From: Susan Baker-Kaplan <suegdi@earthlink.net>
To: Jean Fraser <JF@portlandmaine.gov>
Date: 1/22/2014 9:18 AM
Subject: Letter to the Planning Board re: 118 Congress St Proposed Development

January 21, 2014

Dear Planning Board Members,

LANDSCAPE PLAN
SCALE: 1" = 8'-0"

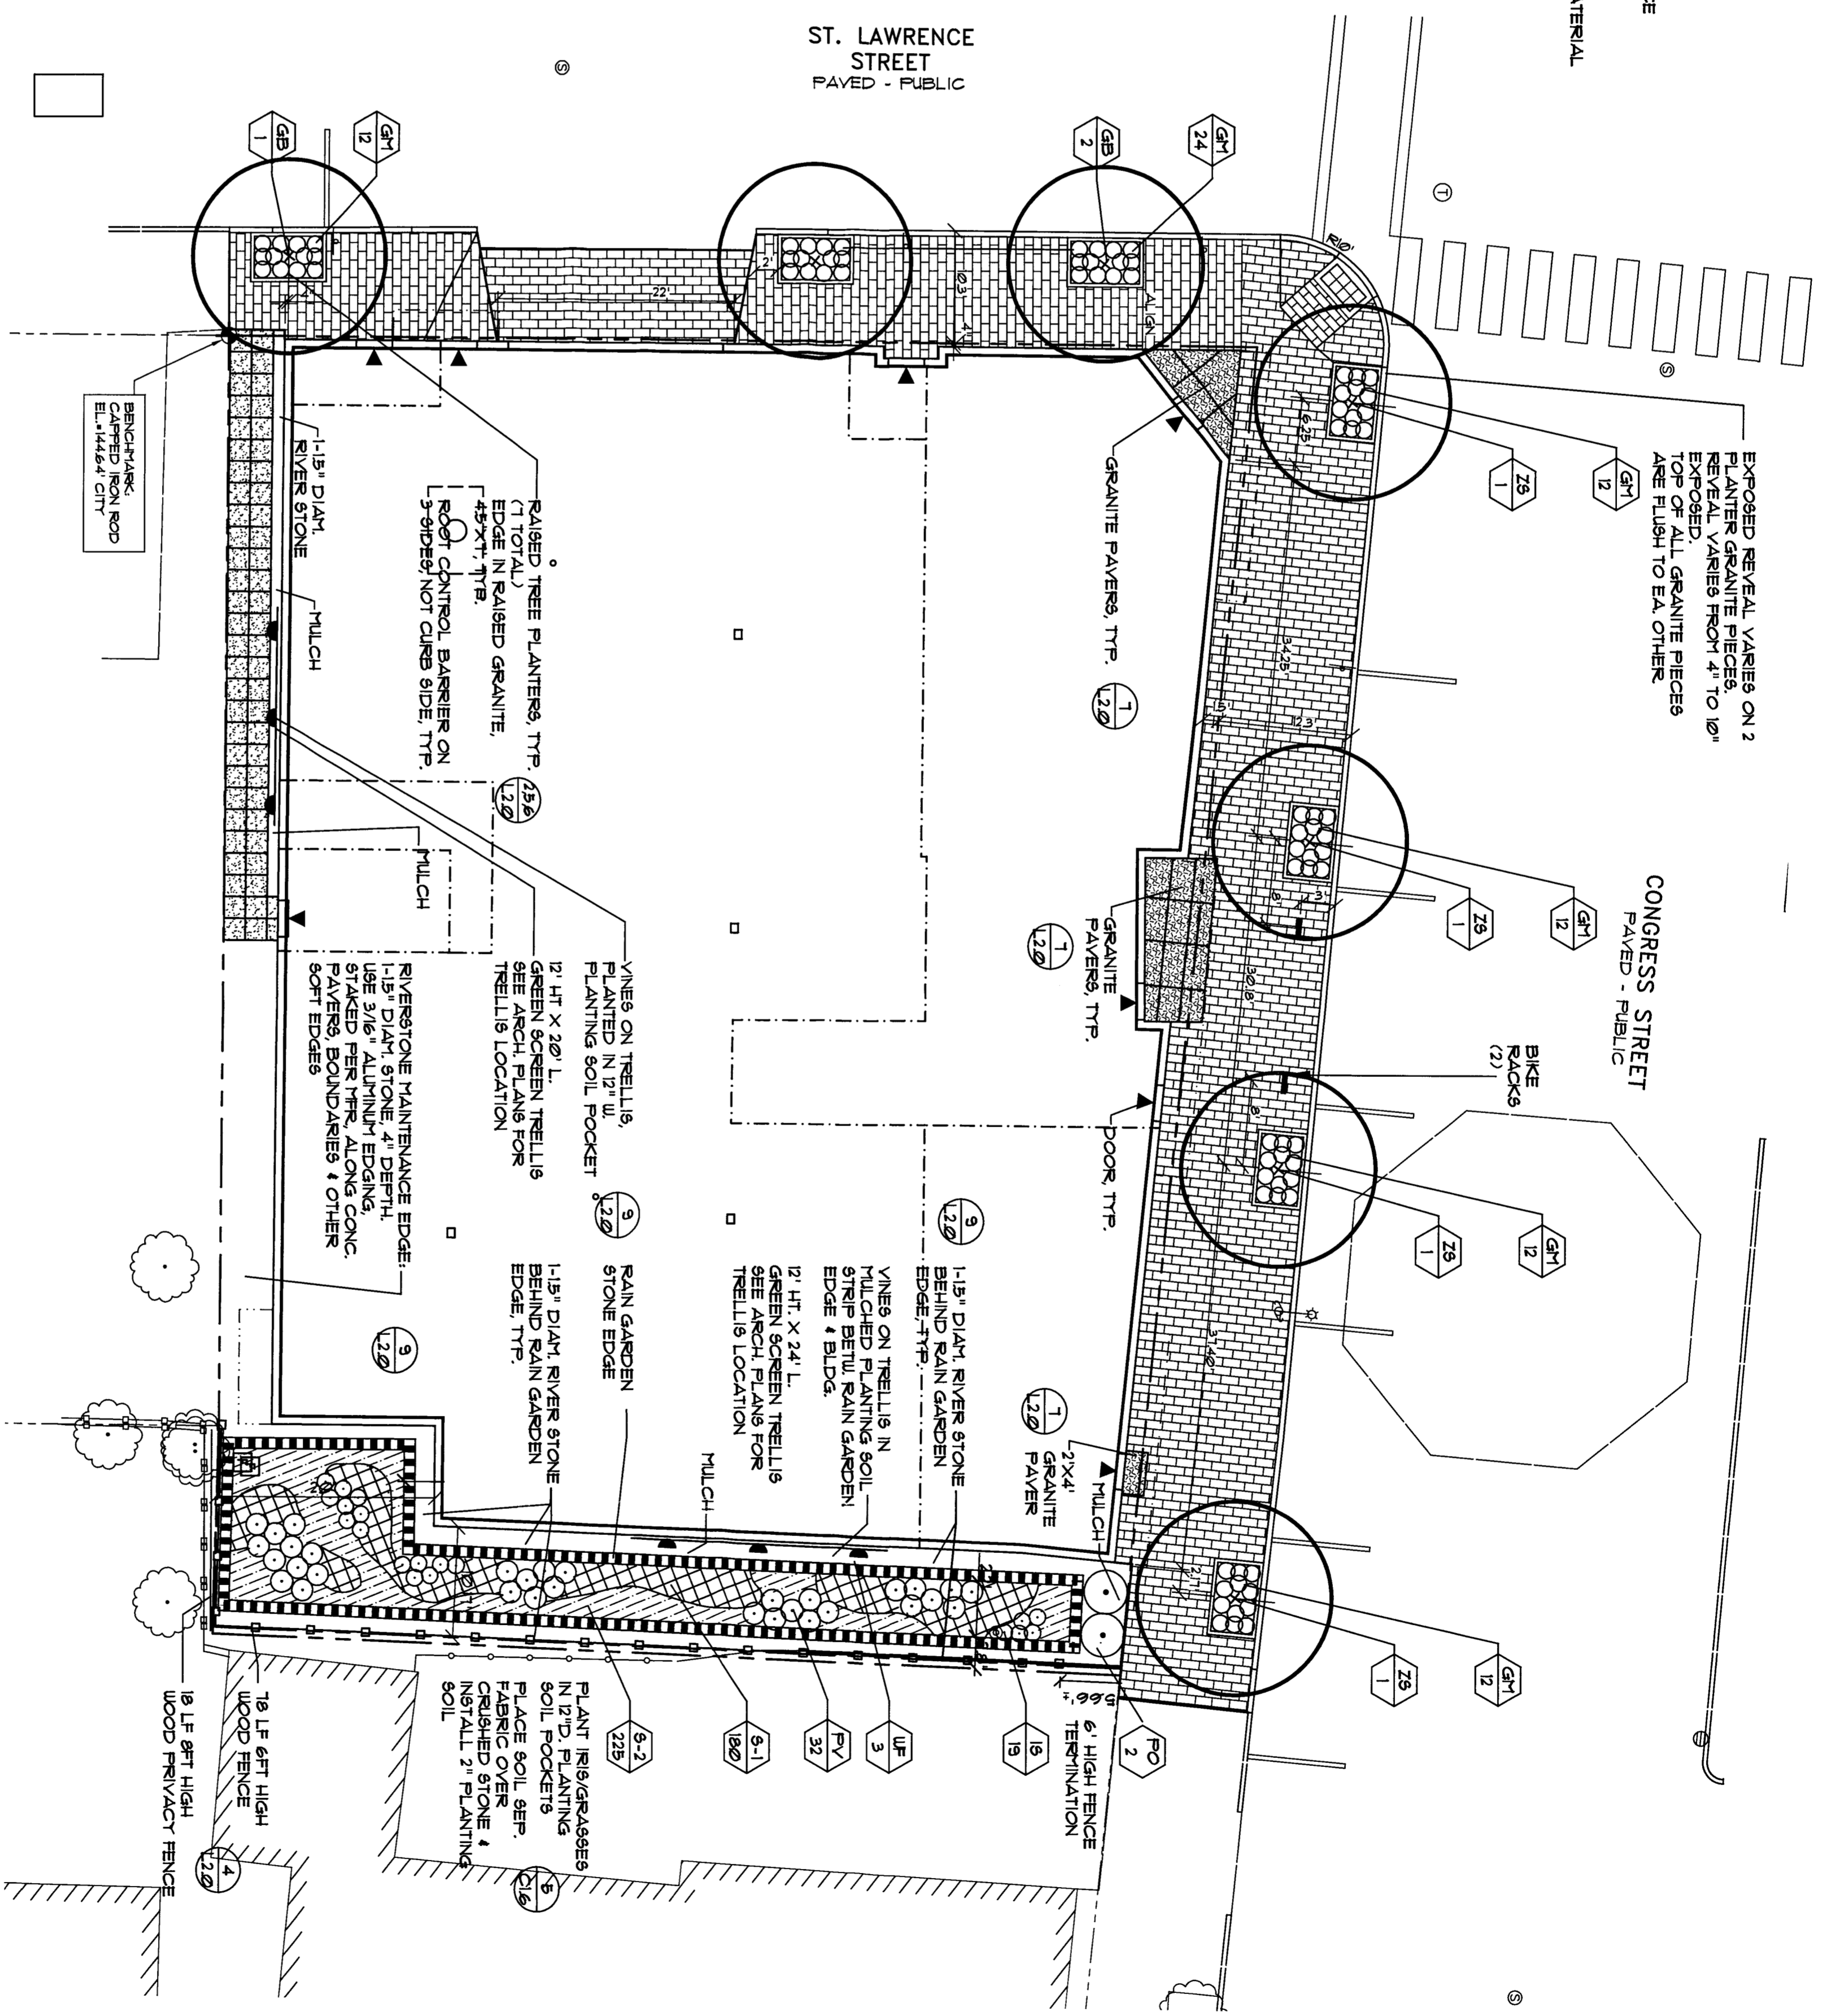
The recent redesign presents an insignificant ONE foot adjustment and a promise to "try to save" an established Pin Oak on St Lawrence Street....a proposal for a rain garden (whatever that is) and possibly planting some wisteria.

(Note: Wisteria is a vine and not a tree. it needs a very sunny location and many years to become established. It is also a favorite food of the brown tail moth, the scourge of the islands and the coast of Maine several years ago.)

1 NORTH ELEVATION
1/8" = 1'-0"

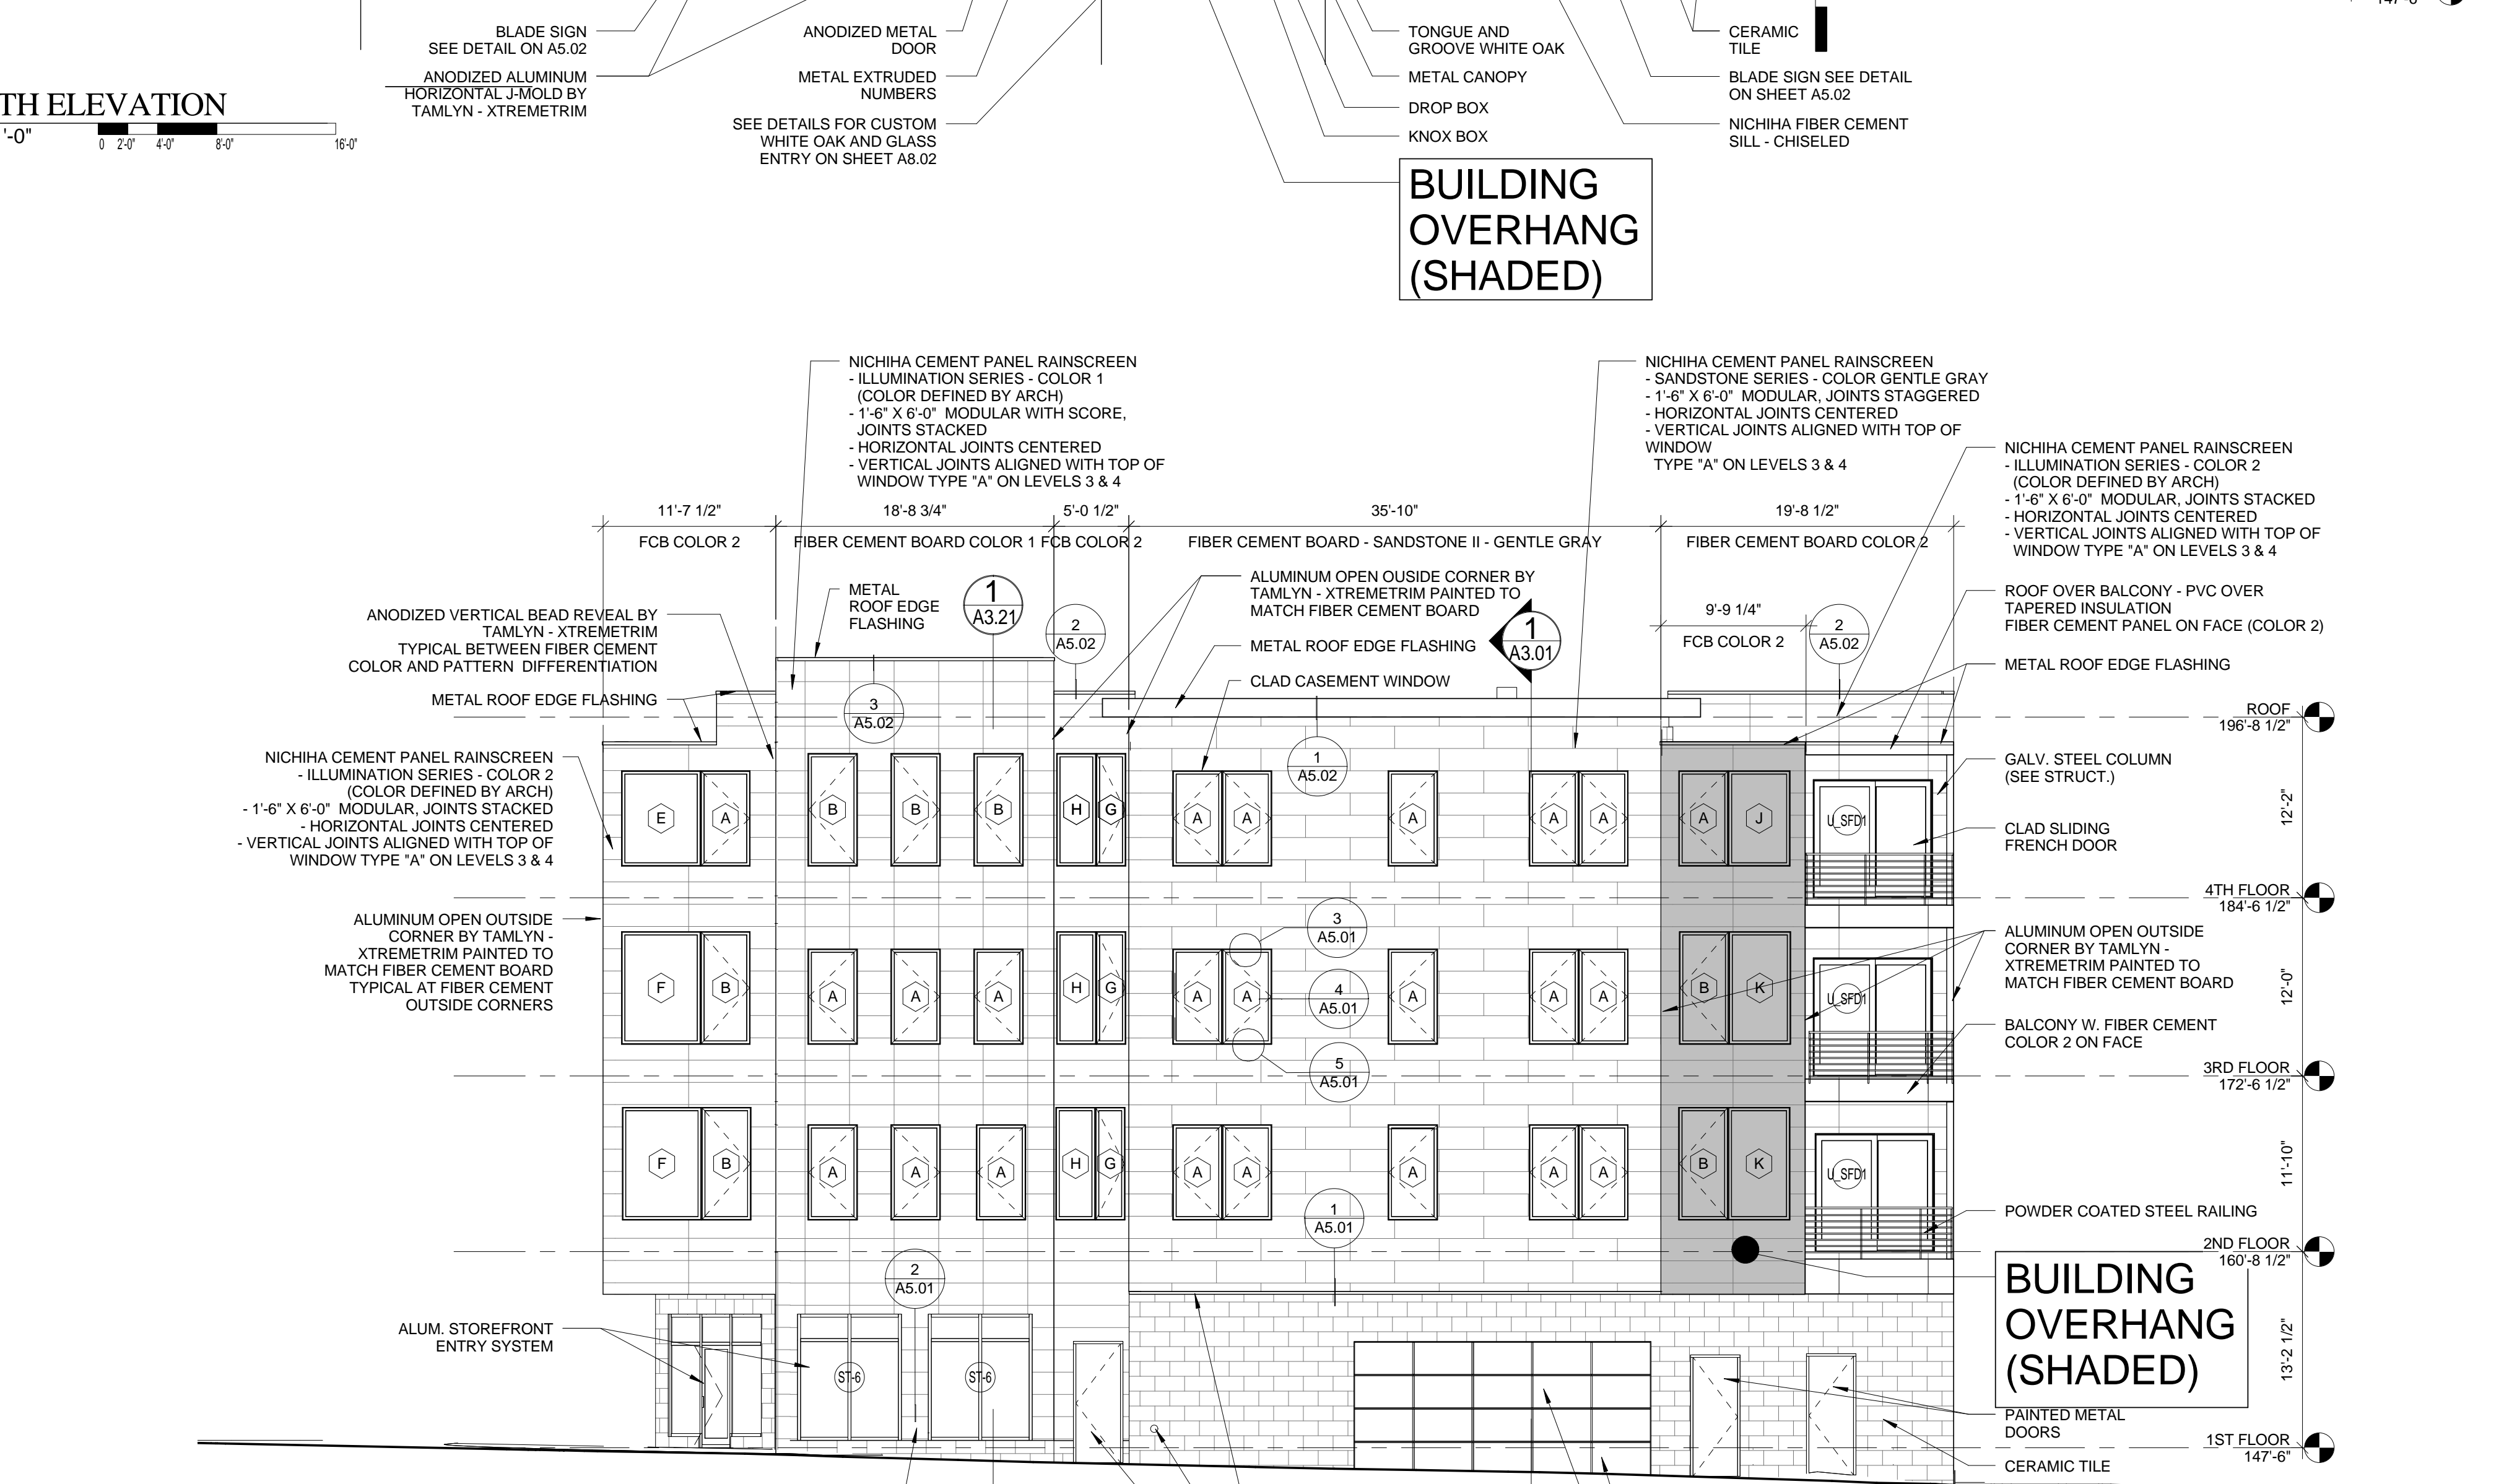
The balconies and overhangs also pose safety issues in terms of falling ice and snow and safe access to public sidewalks below. The easements for the overhangs should be given serious consideration. Are these outcroppings over our public rights of way really necessary? They will greatly enhance the view of the people who will purchase these units but at what cost to the rest of our community? They will not add to scenic or historic beauty to most of us at the pedestrian level.
